From: Amanda Scholes on behalf of Planning.Responses
Sent: 27 April 2018 08:21
To: Planning Scanning
Subject: FW: 1 Seaton Road LU/33/18/HH

From: Mark Jones [REDACTED]
Date: 20 April 2018 at 12:13:18 EEST
To: [REDACTED]
Subject: 1 Seaton Road LU/33/18/HH

ELEVATIONS AS PROPOSED

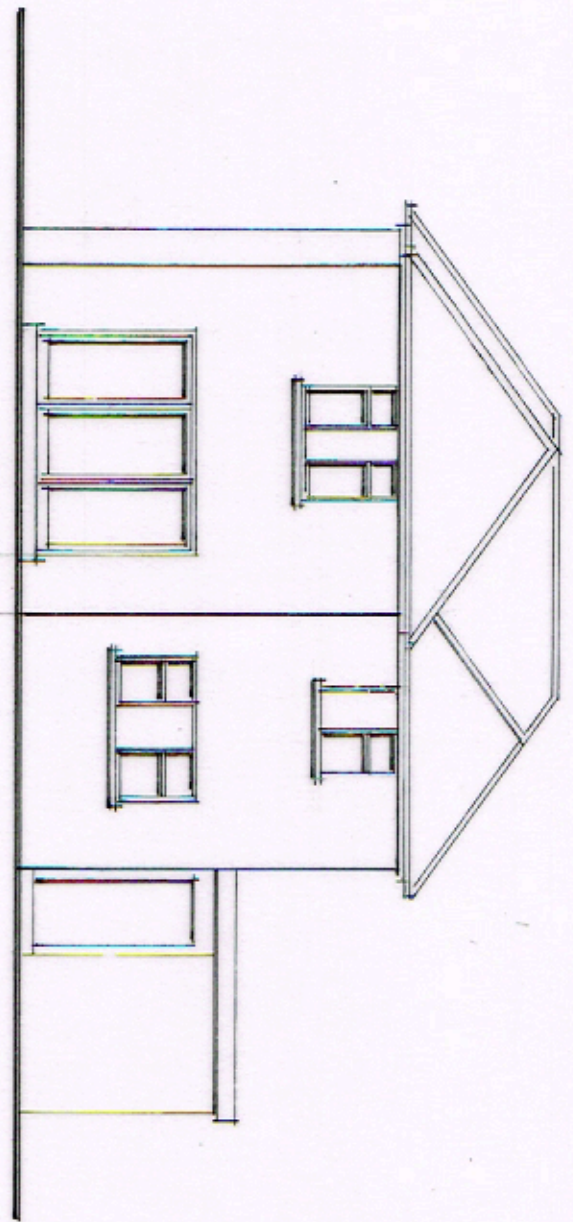
The neighbouring property No.3 has what appears to be a bedroom window in rear elevation set back behind the rear building line of No.1. My concern is the

impact of the two storey extension on the this habitable room. To assess such matters the Council usually take a 45 degree line off the centre point of the nearest window. In this case this line is breached and I feel that the two storey extension will have an adverse impact upon this window and the amenity of the adjoining occupiers.

FIRST FLOOR PLAN AS PROPOSED.

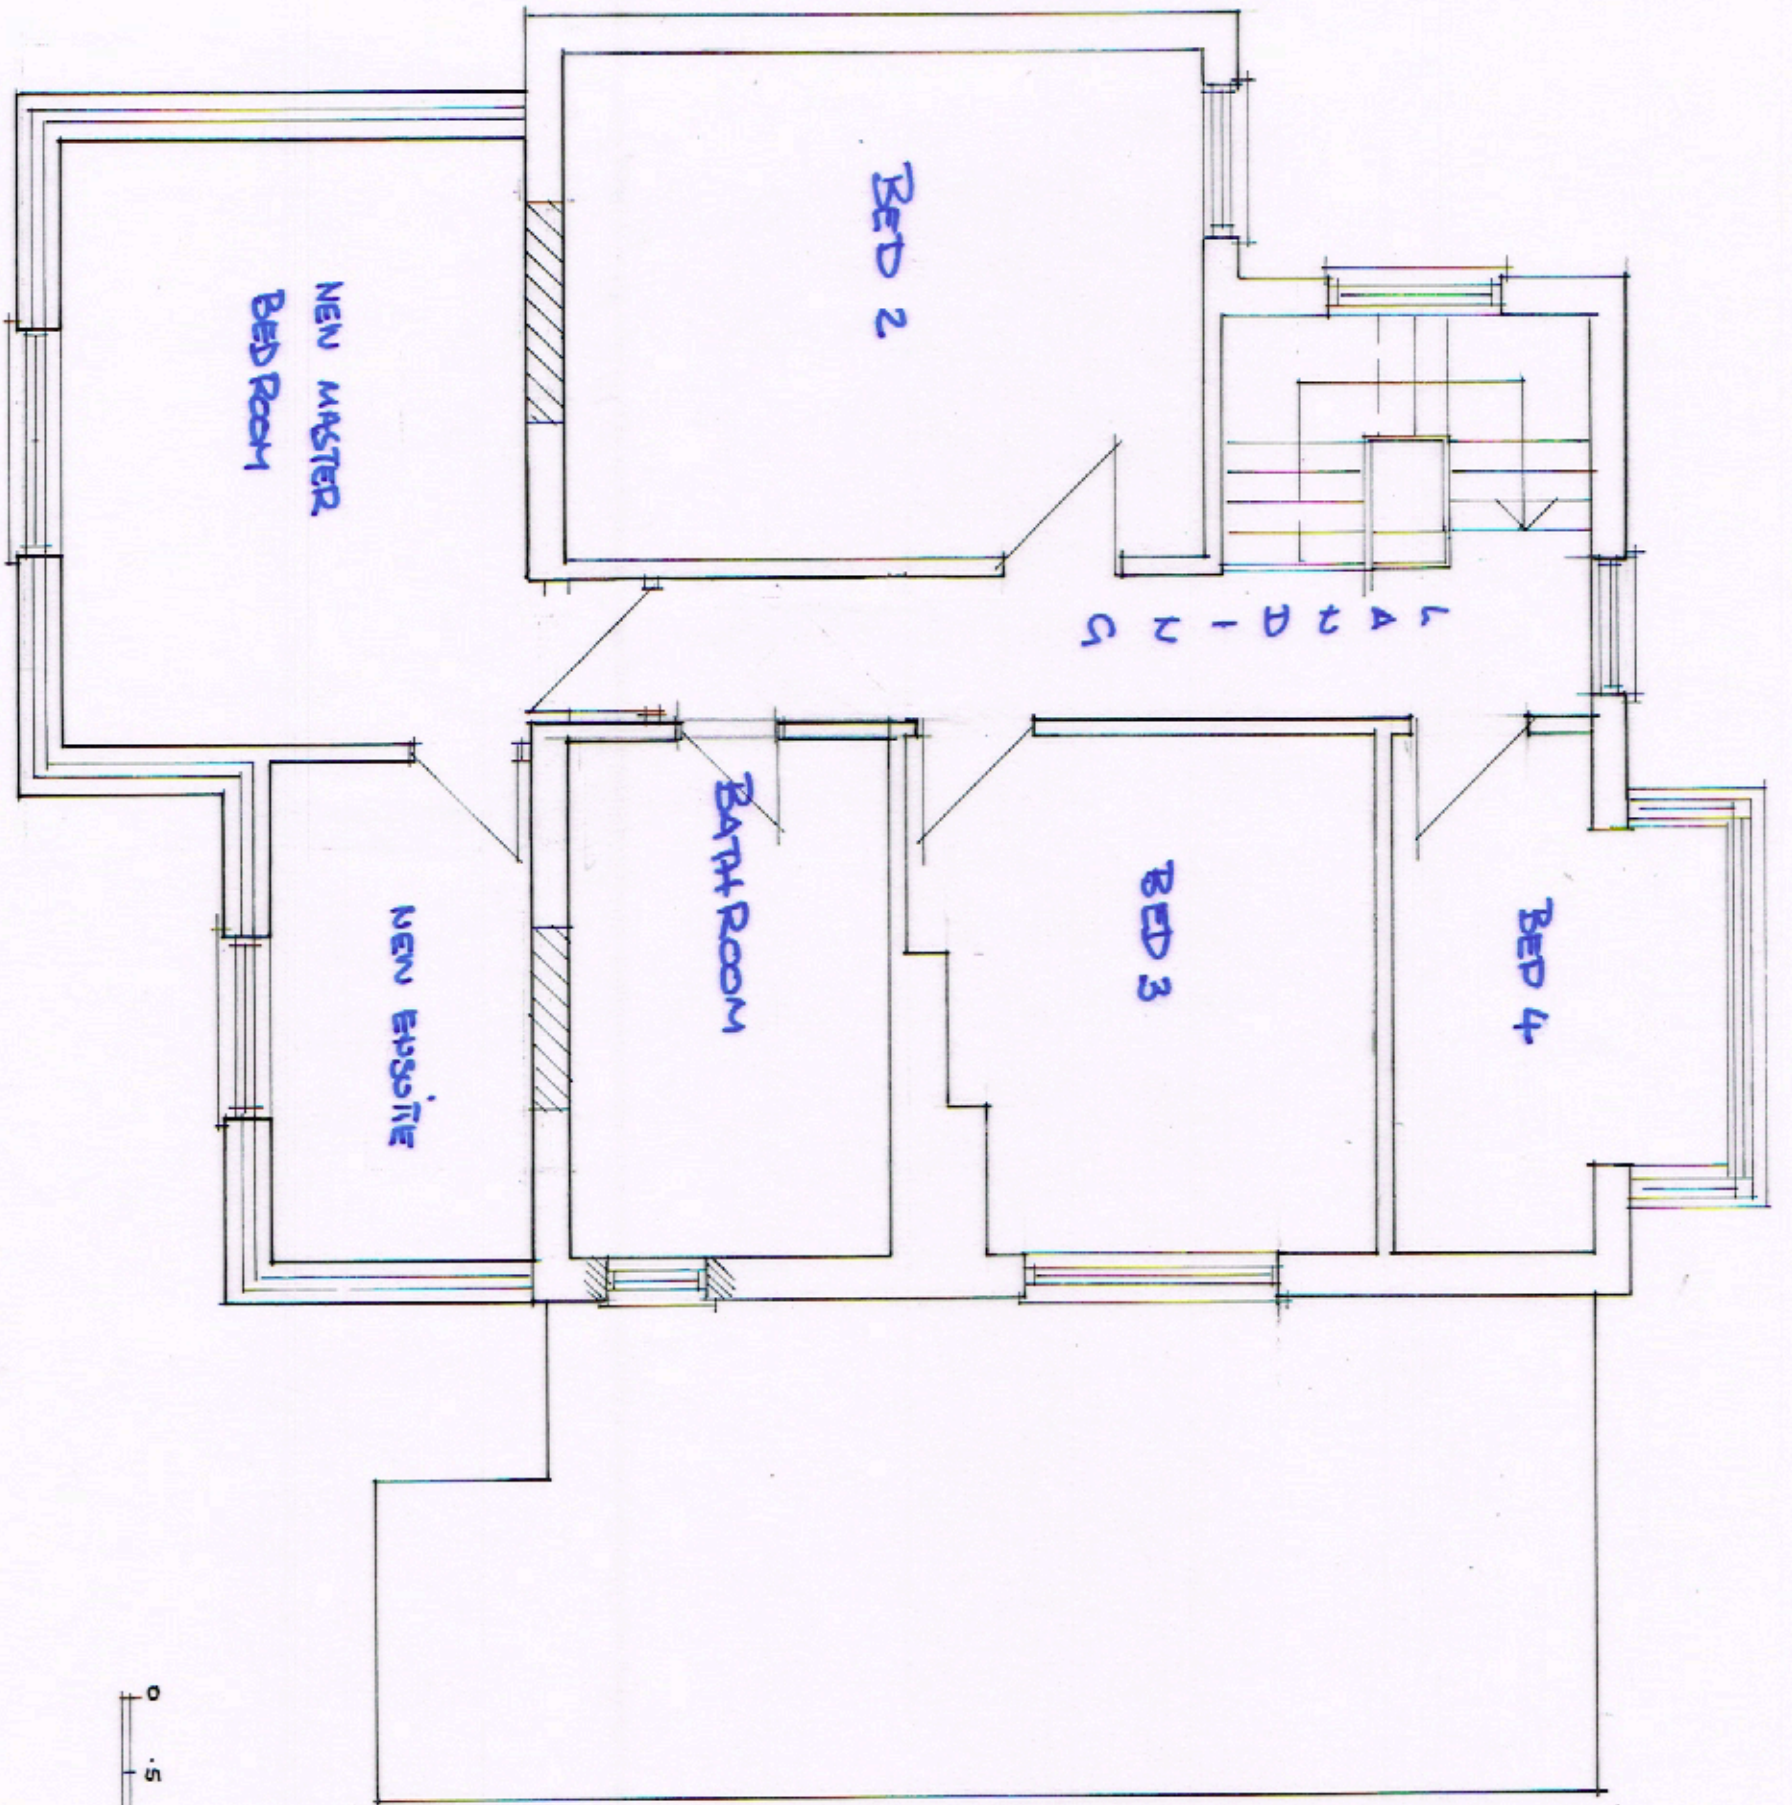
I would welcome your comments on this issue or if possible if the scheme can be amended to address this issue, I appreciate you will need to speak to your client on this matter. I can agree an extension of time to determine the application and suggest we can discuss this if the scheme is to be amended or we can agree an extension of time until 4 May to allow you to consider this. If resolved before this date we would obviously determine sooner
